re: **Geotechnical Assessment – Grading Plan Review**  
**Proposed Multi-Storey Building Complex**  
**1009 Trim Road, Ottawa**

file: PG5336-MEMO.06

- Paterson Group Report PG5336-1 Revision 4, dated May 29, 2025
- Drawing C200 – Site Grading Plan, Revision 2, dated March 25, 2024, prepared by EXP.

PROJECT 1015 TWEDDLE ROAD DEVELOPMENT 1015 TWEDDLE ROAD OTTAWA, ONTARIO.	PROJECT No. OTT-00259629- SURVEY AOV DATE OCT 2024
TITLE SITE GRADING PLAN	DRAWING No. C200

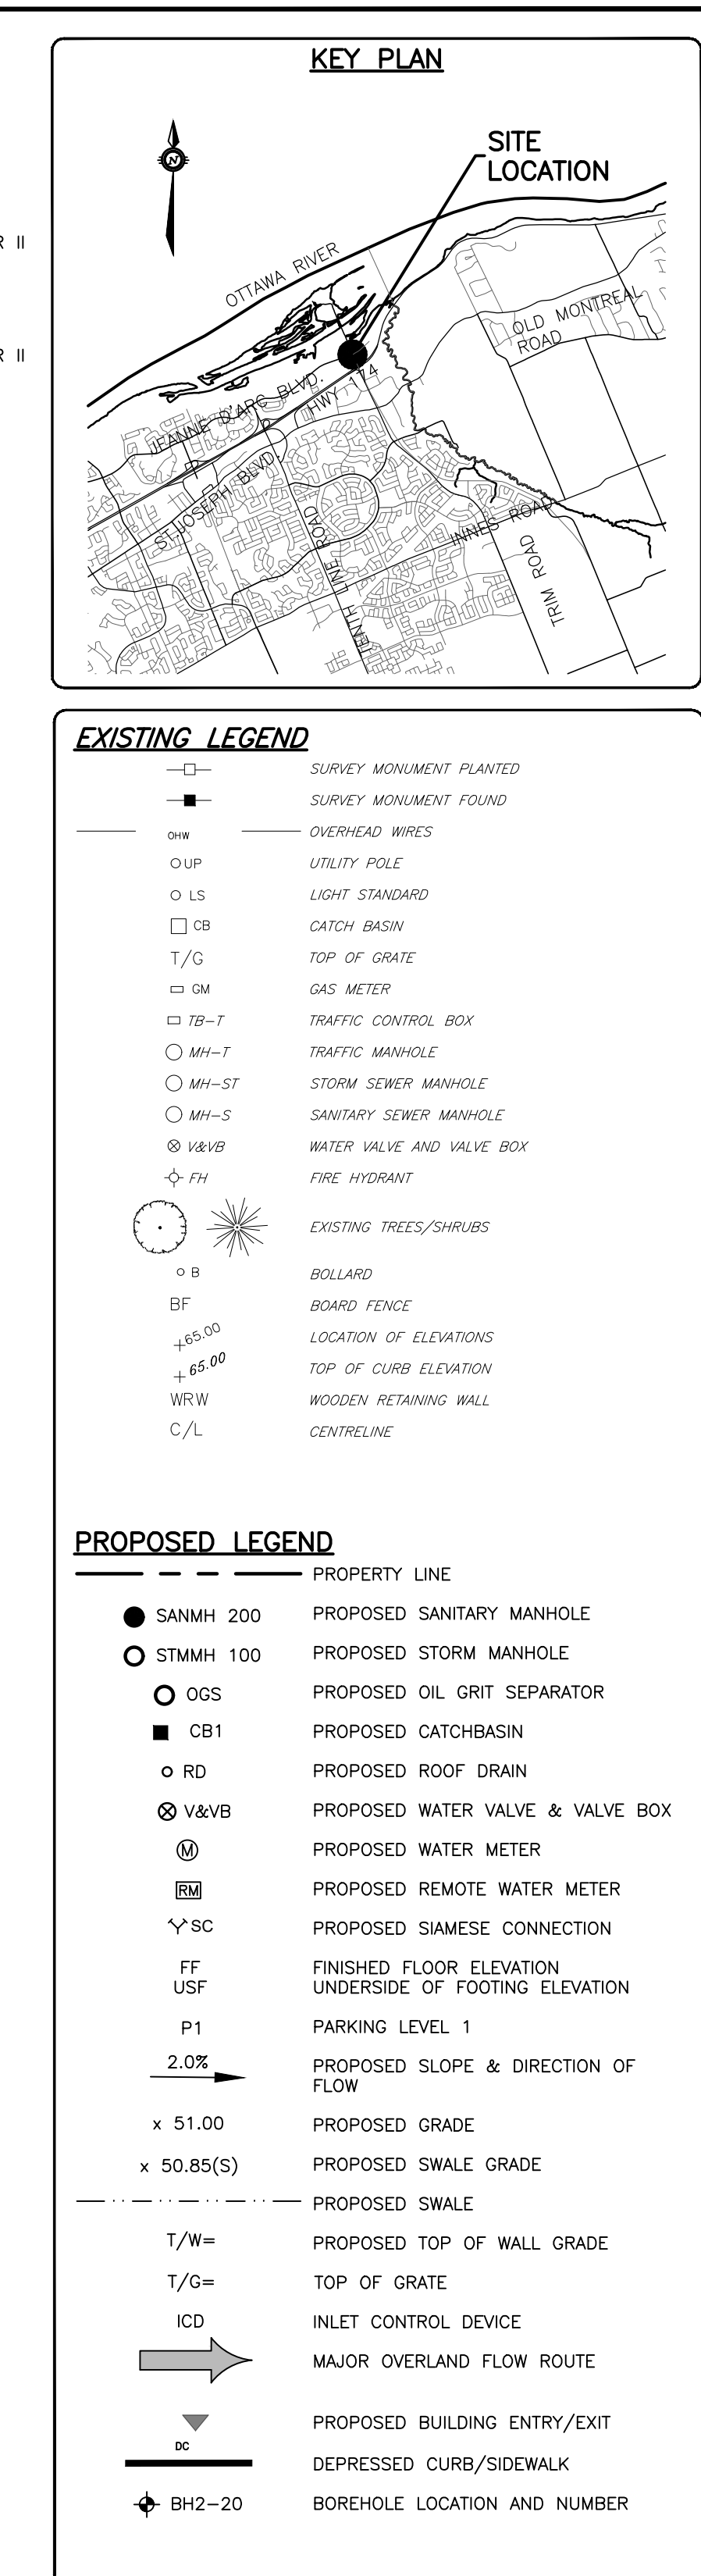
Based on our review of the above-noted grading plan, the proposed finished grades across portions of the site exceed the recommended maximum permissible grade raise of 2.0 m, particularly within the northern section of the property in the vicinity of the proposed retaining walls, and along the western portion of the site near the vehicular access ramp to the underground parking structure. The proposed grade raises in these areas range from approximately 1.0 m to more than 8.0 m above the existing ground surface.

Additionally, the substantial fill heights, particularly adjacent to the proposed retaining walls, will impose significant lateral and vertical loads, which must be carefully considered in the retaining wall design to mitigate long-term settlement, global stability concerns, and potential impacts.

However, since it is expected that the building will be installed on a pile foundation system, the proposed grade raise is not expected to impact the structure.

Based on the review of the proposed grading plan and the subsurface conditions encountered within the subject area—as outlined in Paterson Group Report PG5336-1, Revision 4, dated May 30, 2025—a maximum permissible grade raise of 2.0 m above the native ground surface is recommended. Considering this constraint, two potential solutions can be evaluated for the proposed development.

To mitigate settlement associated with the consolidation of underlying clay soils, lightweight fill (LWF) may be considered as backfill material behind selected retaining walls.

The LWF should consist of EPS 12 blocks, with the final thickness profile to be determined following the completion of the retaining wall design. As a general guideline, the thickness of the LWF is expected to range from 1 to 5 m, depending on the area-specific grade raise and geotechnical conditions.

As an alternative to lightweight fill (LWF), consideration may be given to the implementation of a preloading and surcharging program to manage grade raise-induced settlement.

This ground improvement technique involves the placement of engineered granular fill exceeding the final design grade elevation to act as a surcharge load, thereby inducing accelerated consolidation of the underlying compressible soils.

The surcharge is maintained for a predetermined duration—based on settlement monitoring and consolidation modeling—until a target percentage of primary settlement (e.g., 90–95%) is achieved. Once the preload objectives are met, the excess surcharge fill is removed, and site grading can proceed.
